CITY OF ALBUQUERQUE

January 13, 2017

RE: **Jackson Middle School
Grading and Drainage Plan
Engineer's Stamp Date 11-11-16 (File: J21D029)**

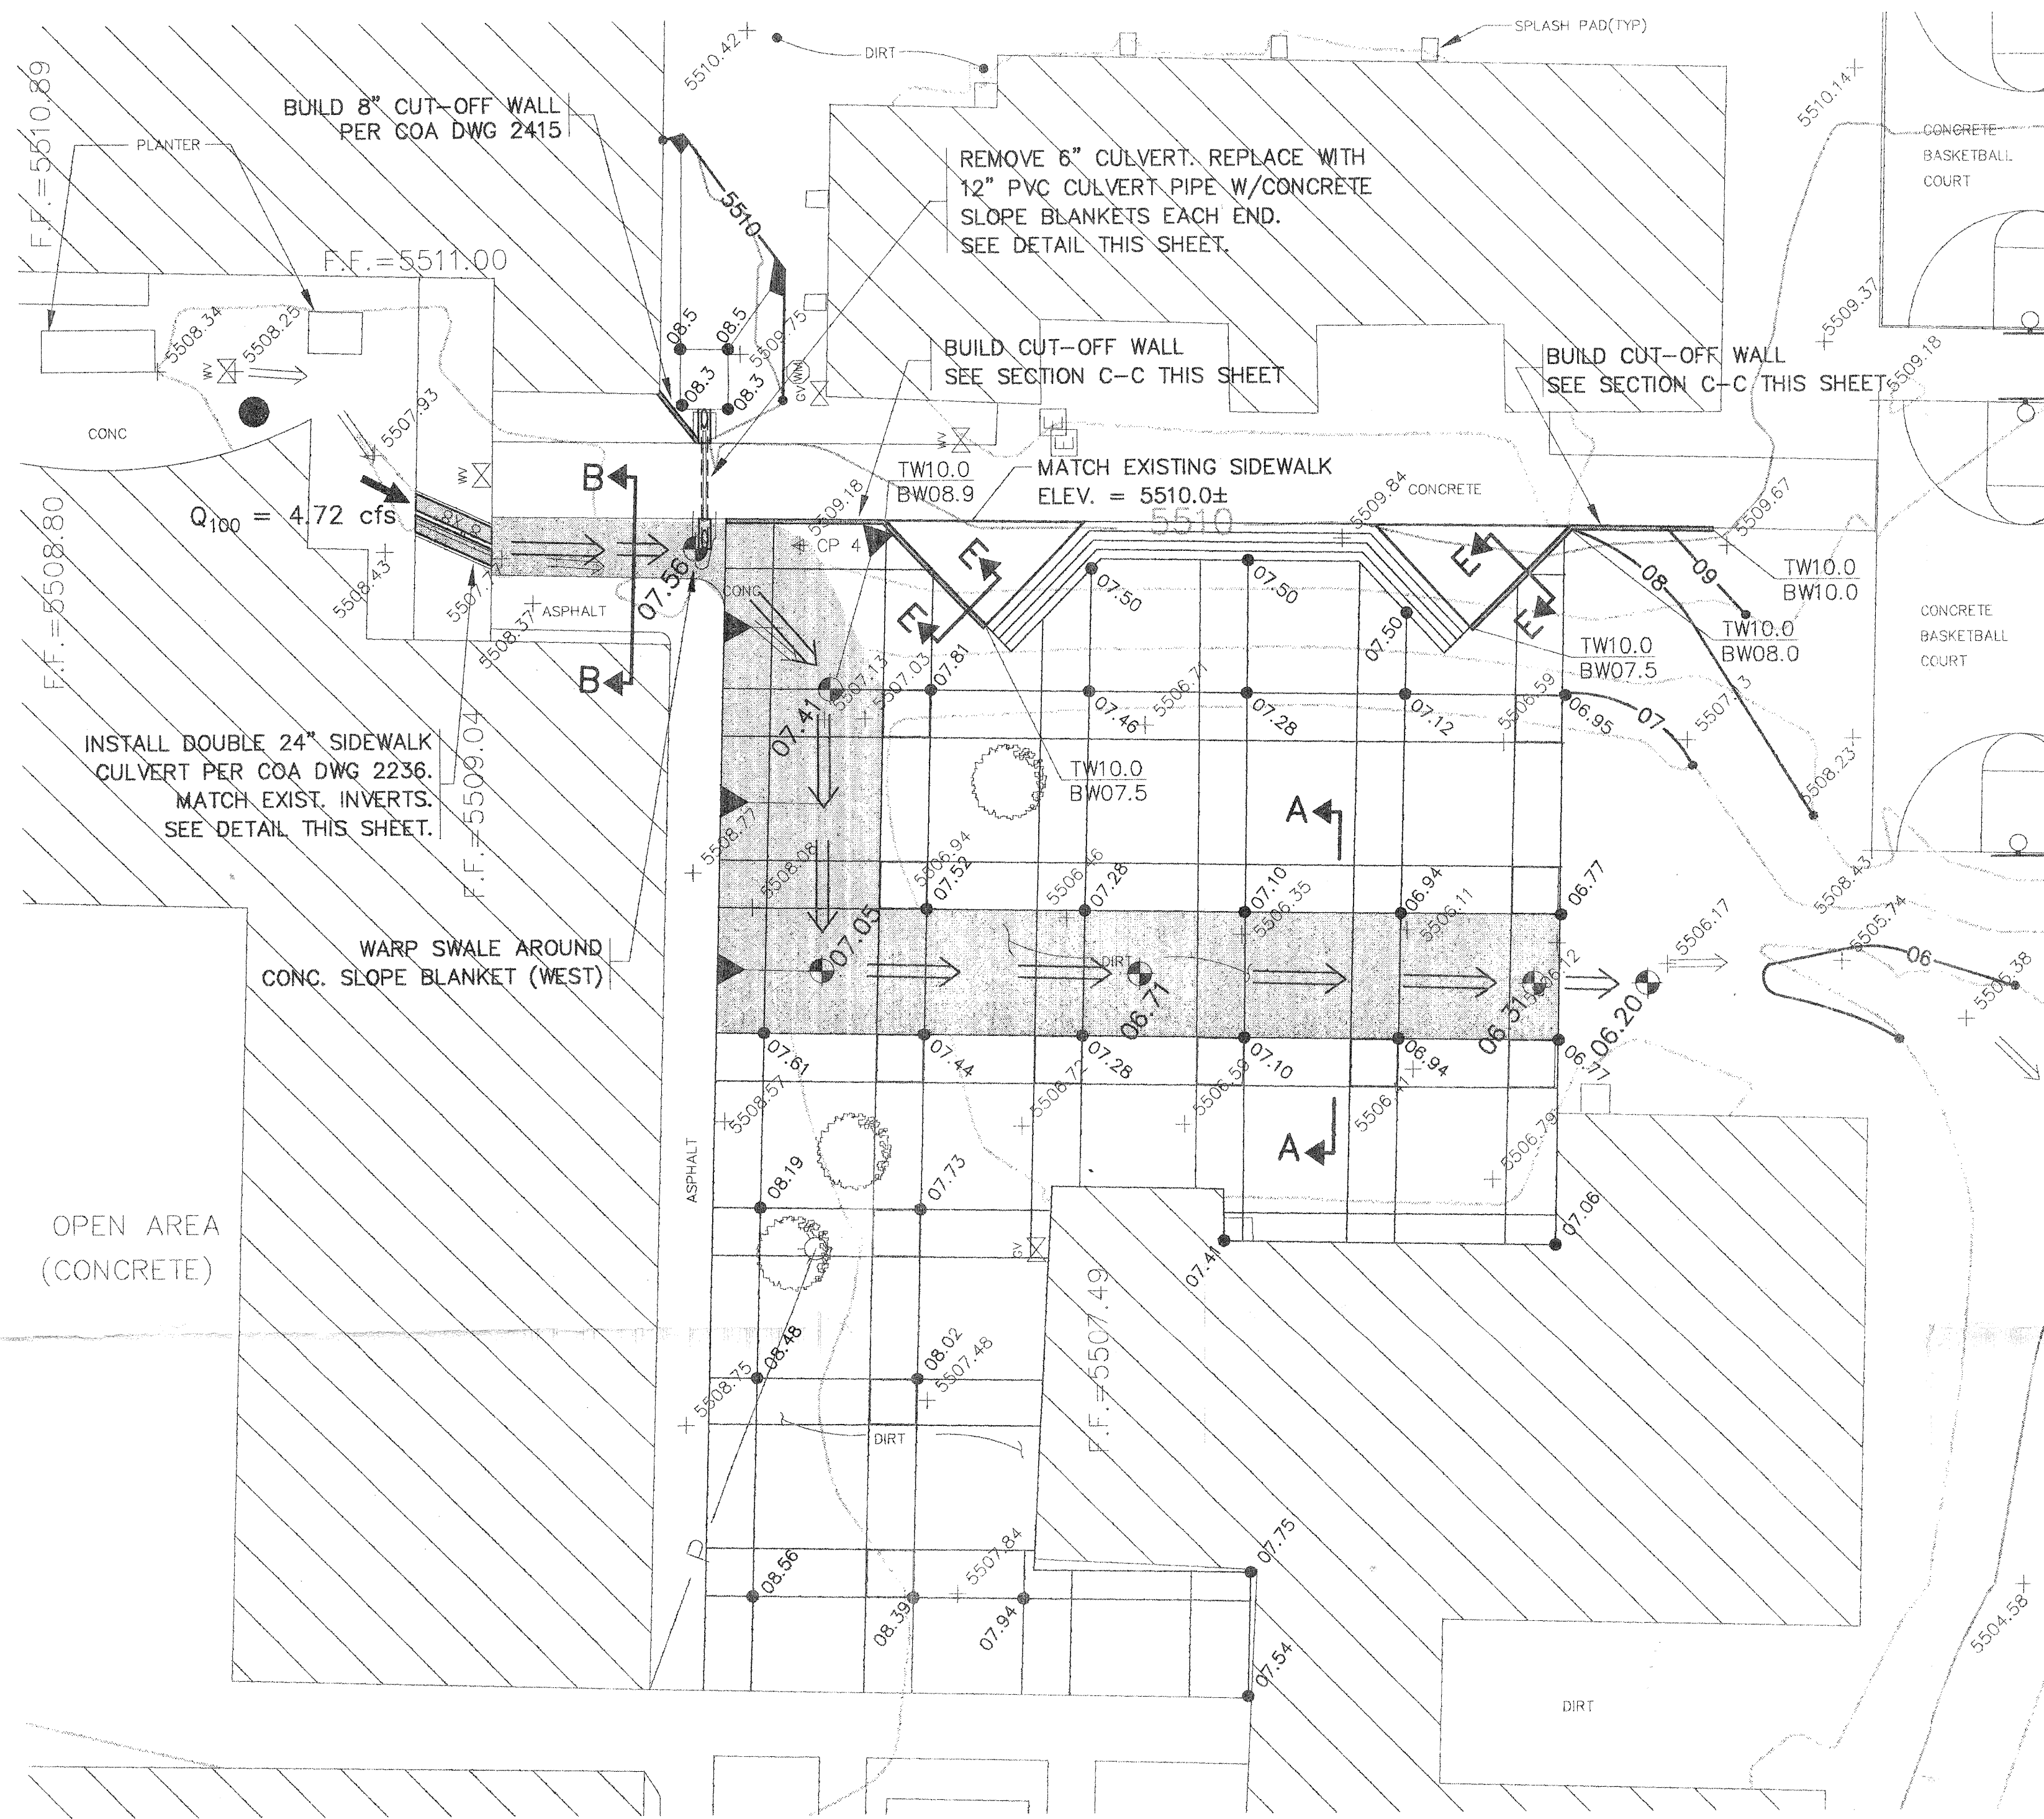
1. The Drainage Approach concludes with flows from the shallow depressed landscaping area being directed northward into a parking area and toward Comanche. No mention of directing flows into the storm drain and southwest towards the detention pond is made. Clarify the last portion of the Drainage Approach to match what is shown on drawings.

The approach as shown on drawings, acceptably conveys flows from the impervious areas through storm drain or overland, to the enlarged detention pond, whose outfall is Blume Street on City Right-of-Way. Additionally, it is recommended that erosion along the existing concrete rundown to the detention pond is corrected as part of this work.
